Eldorado Springs at Cheyenne Mountain Fil. No. 1

ADMINISTRATIVE SITE DEVELOPMENT PLAN - ELEVATIONS

Elevation Plans_V2.pdf Markup Summary

ARCHITECTURAL
ELEVATIONS
SDP14
SHEET 14 OF 16
ALC PROJECT # 19-020

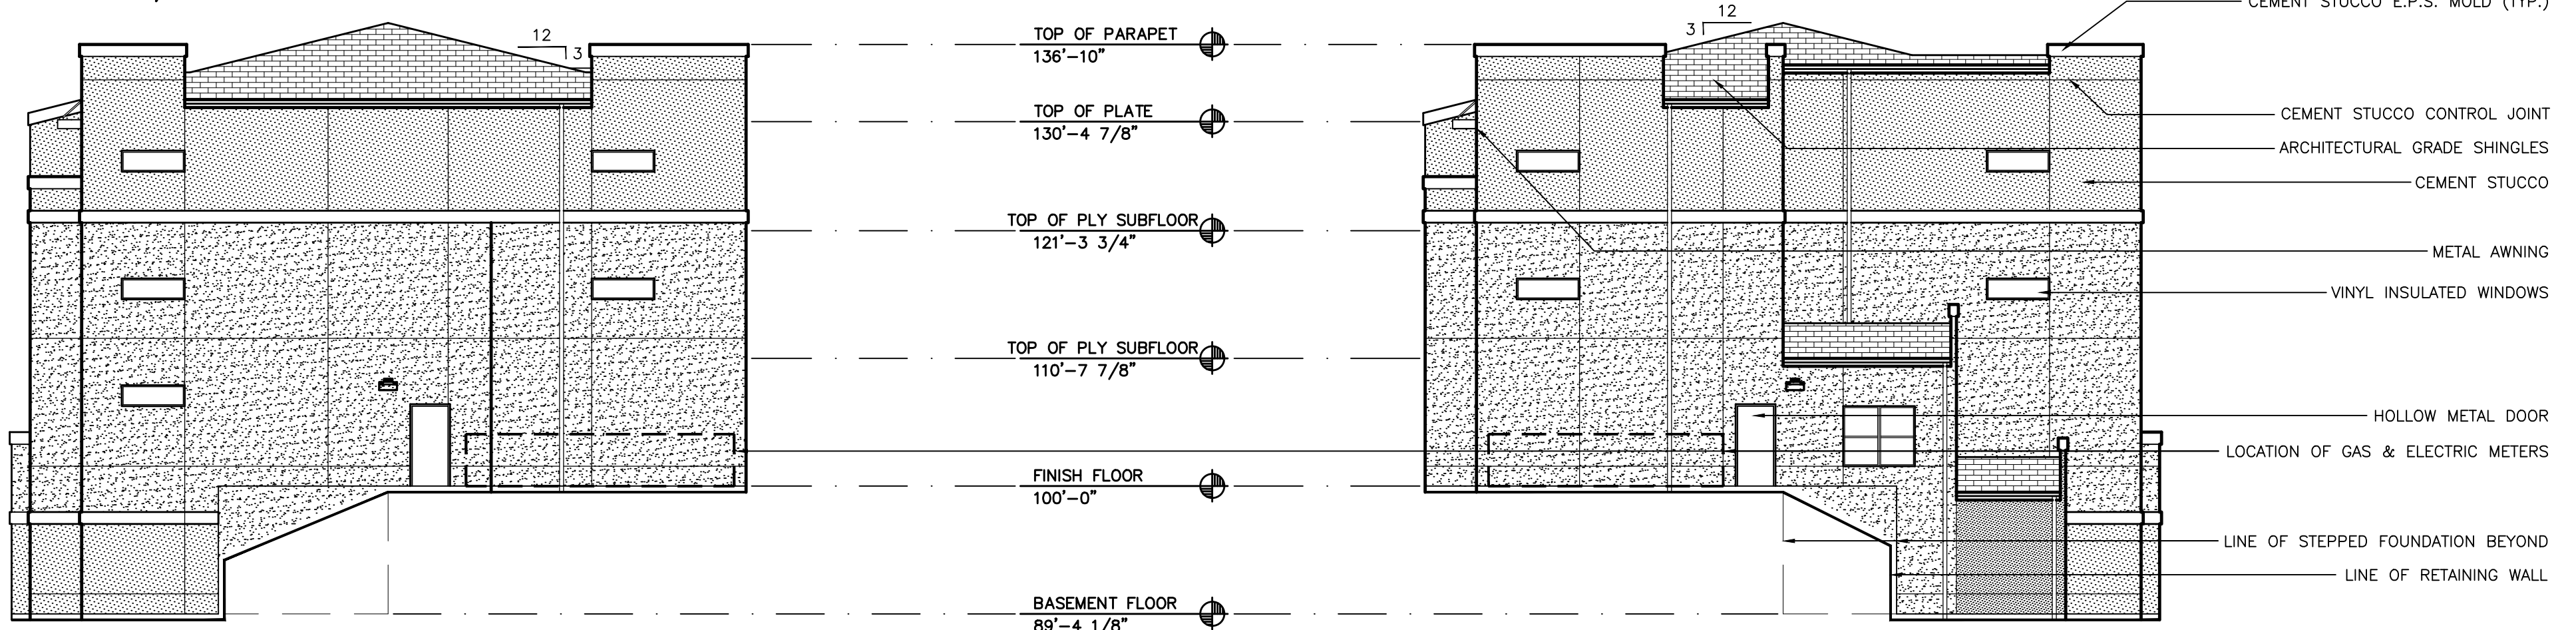
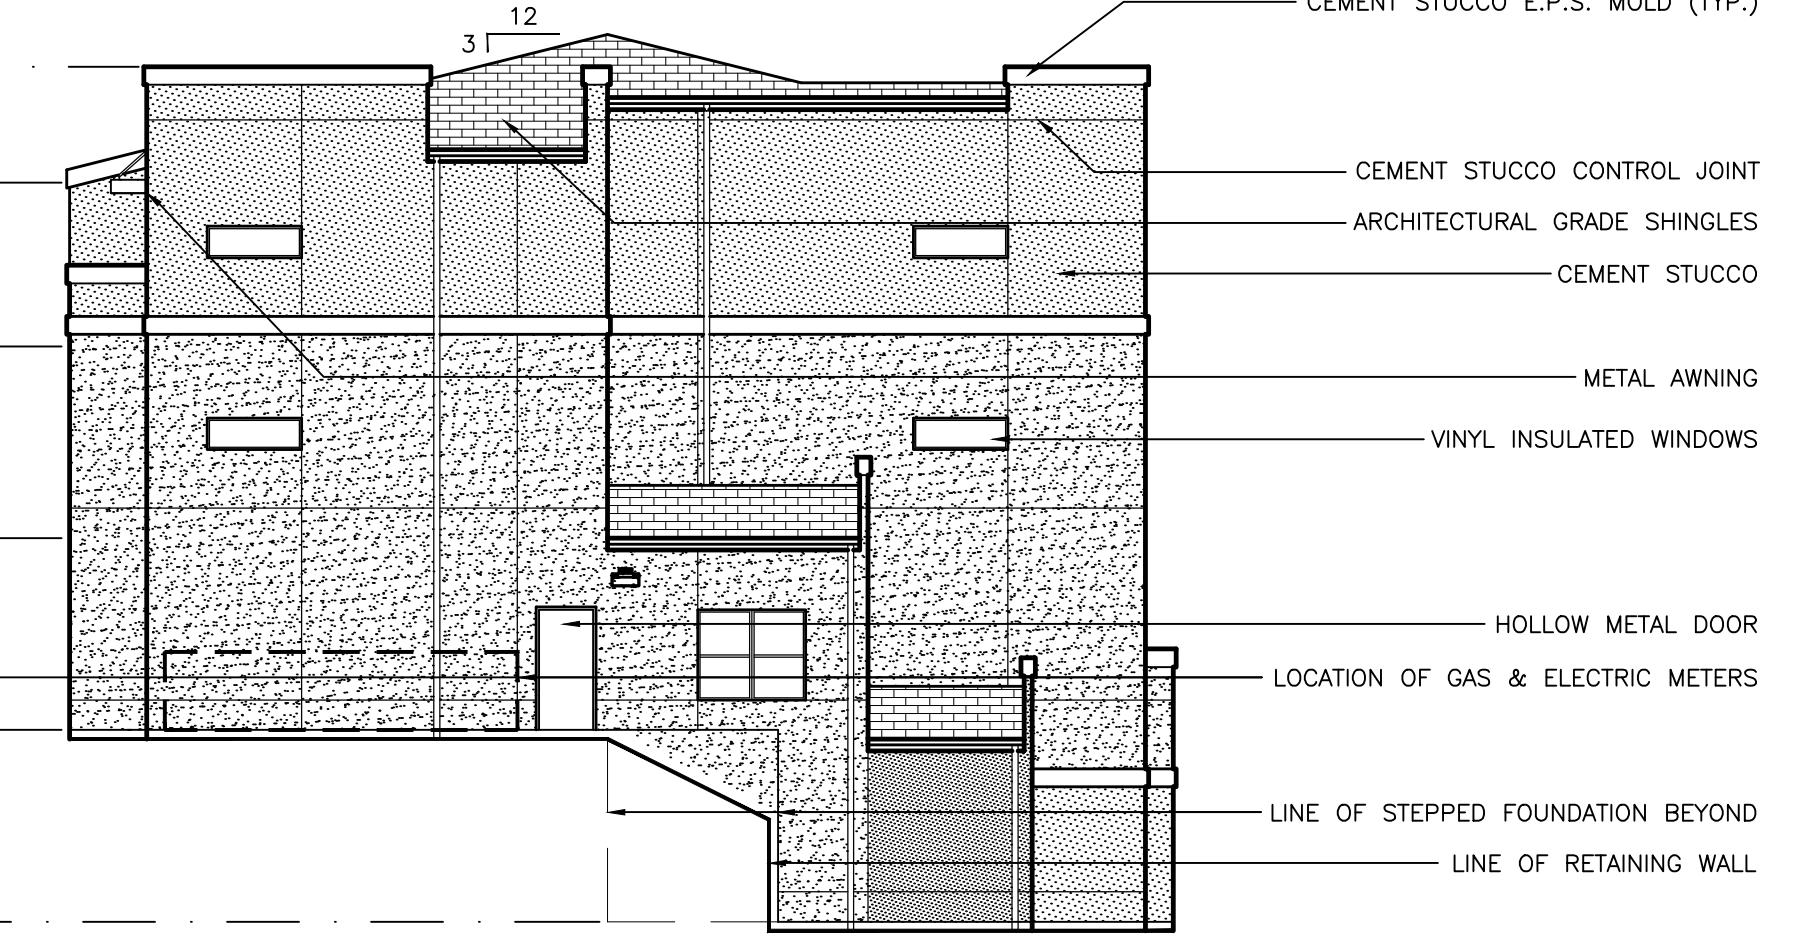
update, needs to be INDEPENDENCE PLACE AT
CHEYENNE MOUNTAIN FIL NO 1

ARCHITECTURAL ELEVATIONS
SDP15
 SHEET 15 OF 16
 ALC PROJECT # 19-020

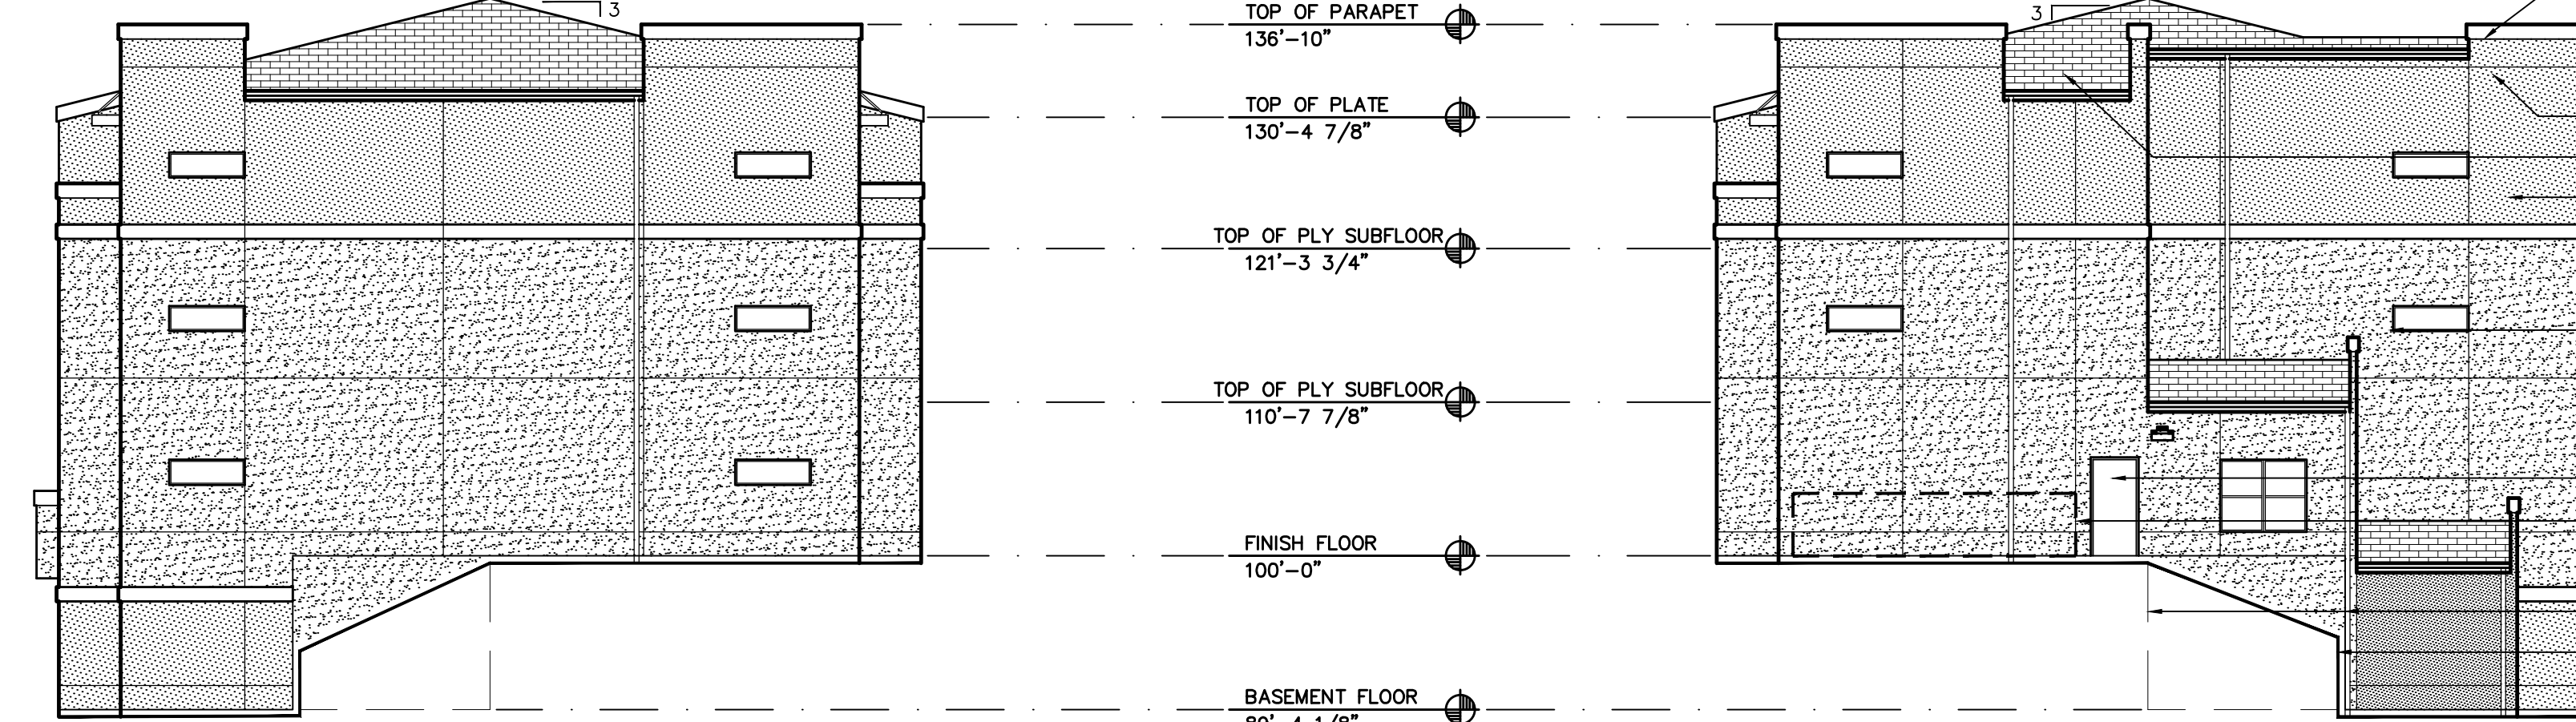
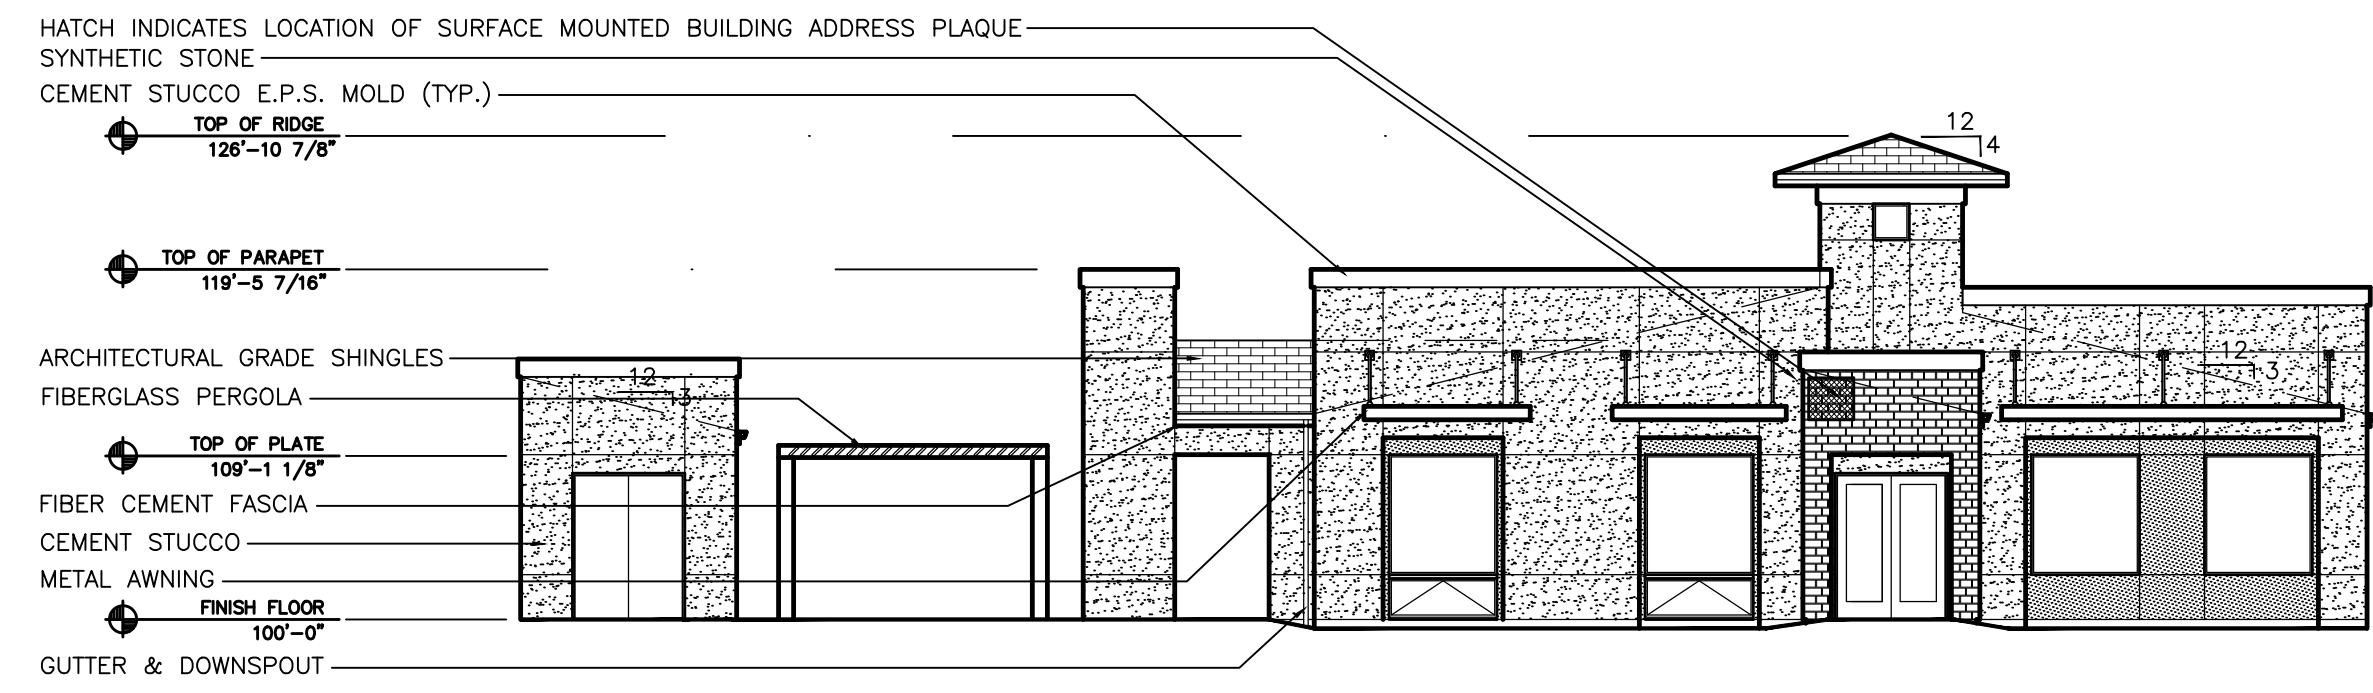
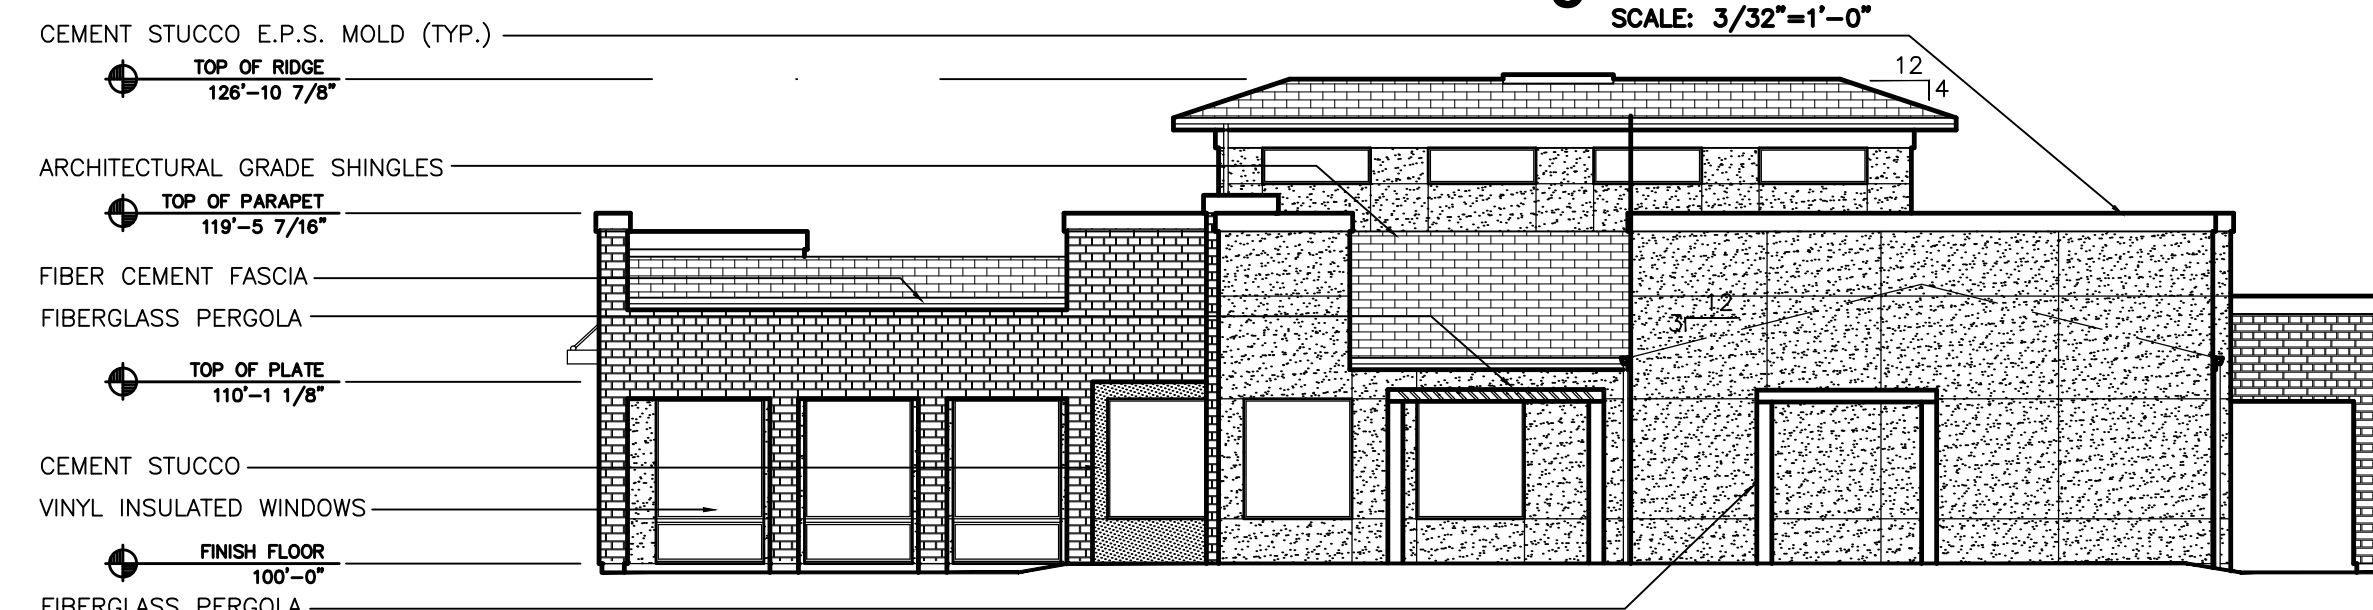
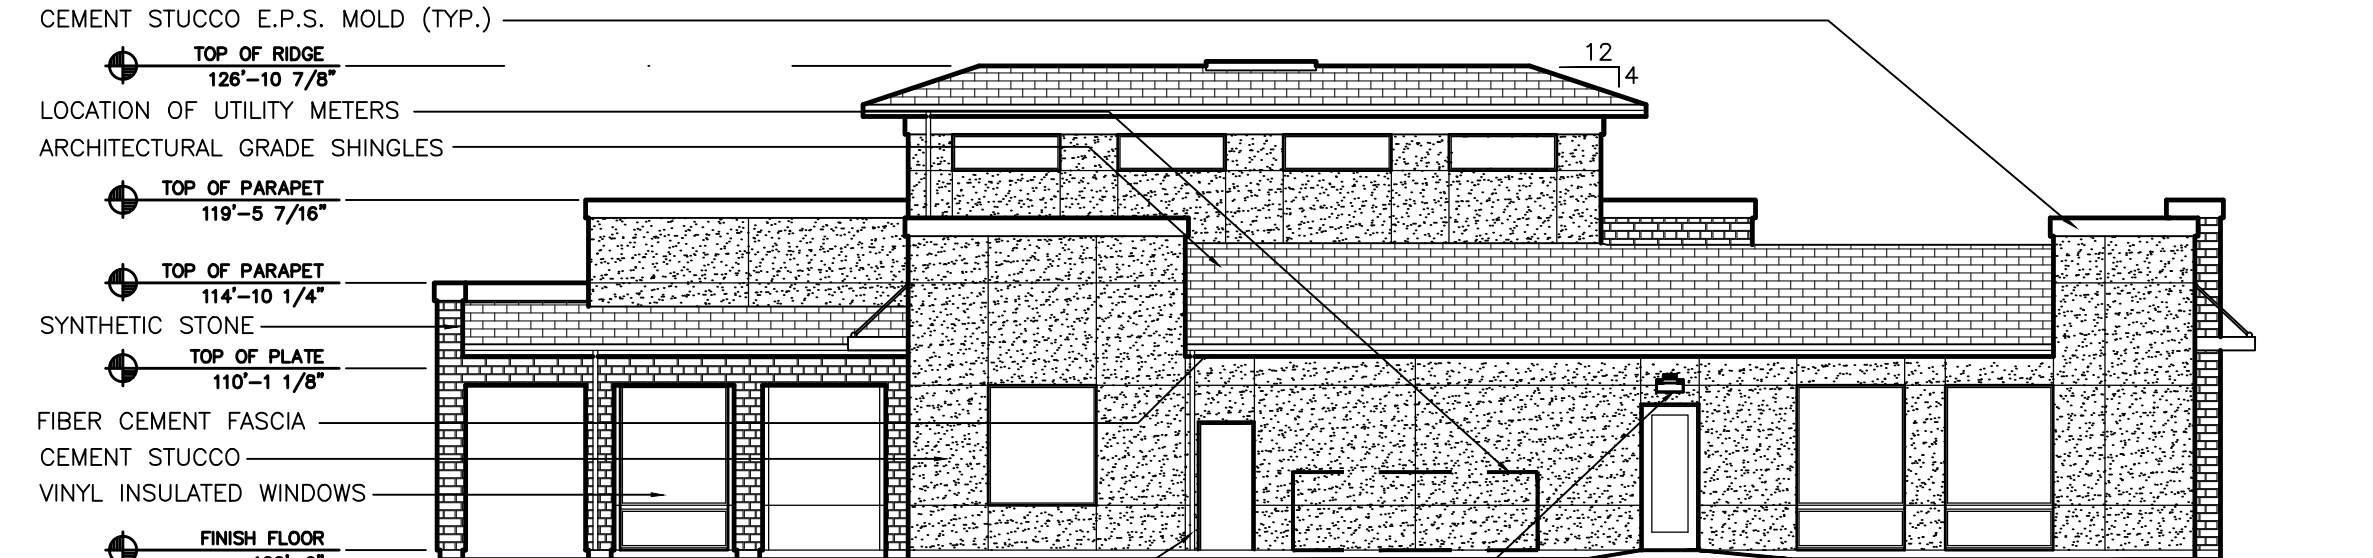
update, needs to be INDEPENDENCE PLACE AT
CHEYENNE MOUNTAIN FIL NO 1
